21st September 2020

Application No: WA/43/20/HH
Site Address: 9 Long Mead Walberton BN18 0QG
Description of works: Extend length of existing porch by 2 square metres, move exiting gate in line with porch and add security fence panel. Add three low panel to existing wall.

Thank you for your internet representation made on 20th September 2020 which has been recorded as an objection with the comments as follows:

Relocated Gates plus Security Fence & 3 Small Fences

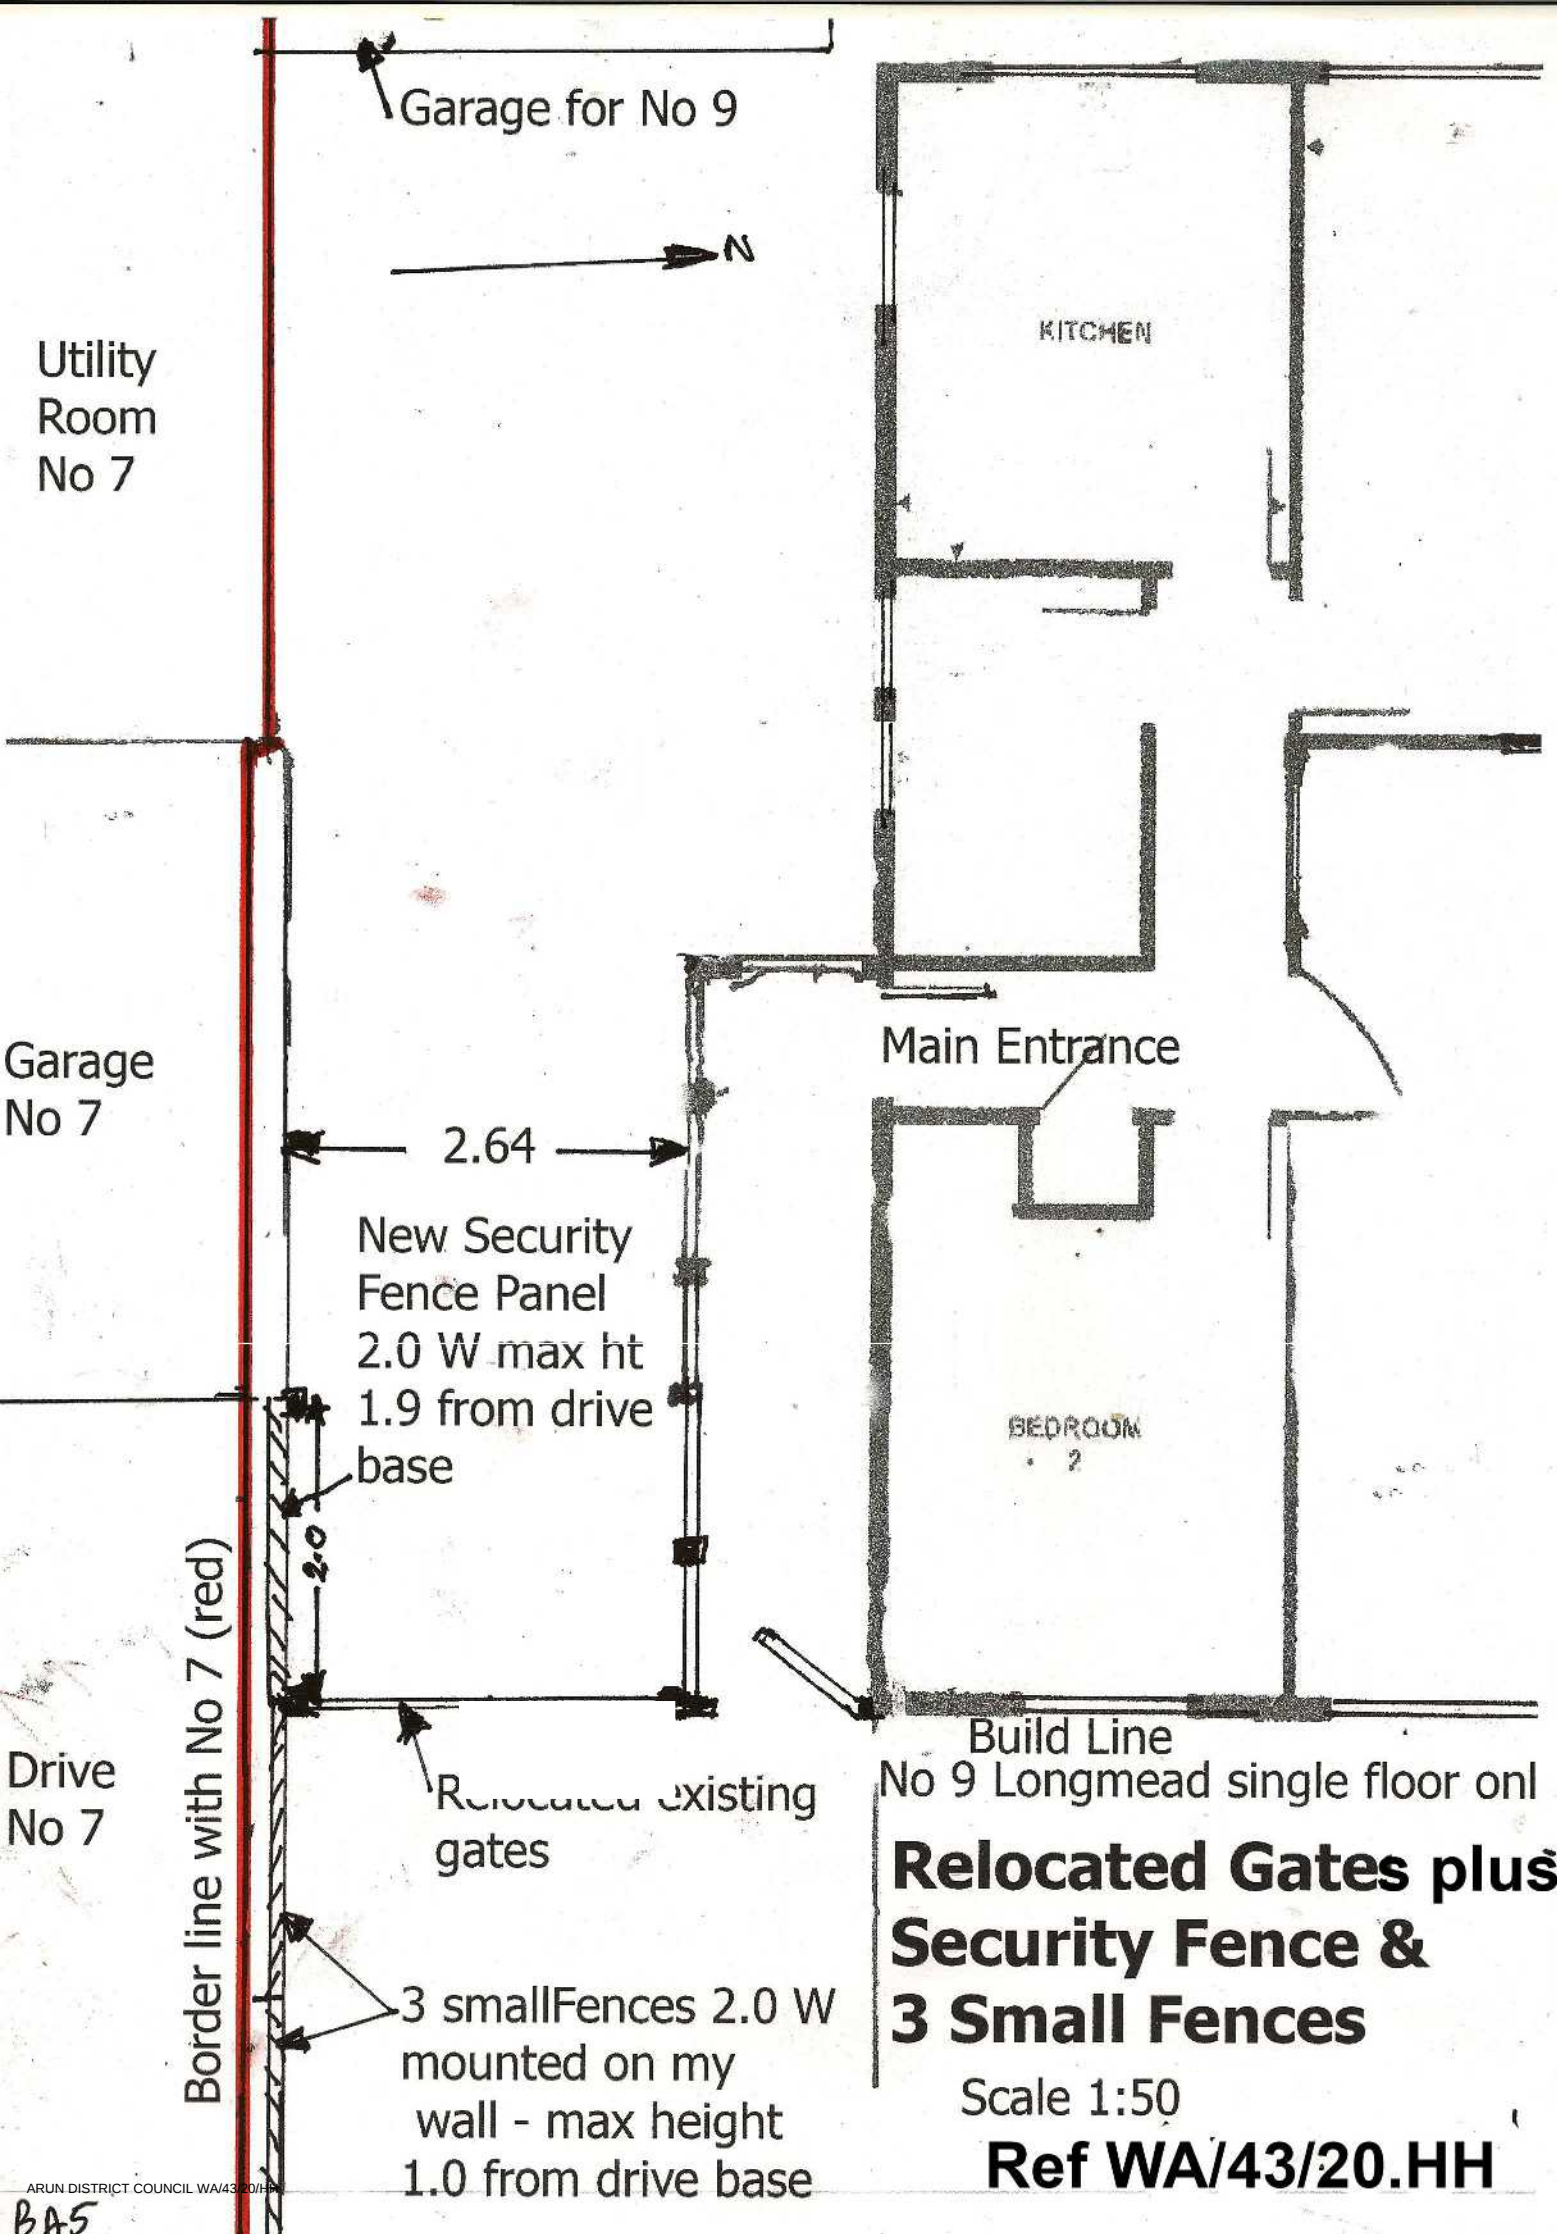
We see from the proposed planning works to be carried out by Mr Allsopp that it includes several fences and security gates. We have no issue with the bringing forward of his gates to the front of his porch line. However his plans include the erection of fencing along the retaining wall between our two properties.

This wall is a shared wall and we have not been asked for permission to erect it. We refuse our consent to the placing of fencing along the lower part of the wall which reaches down to the end of our driveway to where it meets the public footpath. Our reasons are as follows:

1. This would spoil the aspect of our property.
 2. Fencing of this nature is not in keeping with any other driveways in our cul-de-sac which are all open plan as indicated by the covenant on the land when the properties were built.
- If the plans were to be approved for the lower fencing on top of the wall this would set a precedent and one assumes all the other householders could do the same. On speaking with our neighbours (other than Mr Allsopp who refuses to speak to us) the general consensus was they like the open plan aspects we all enjoy at present.
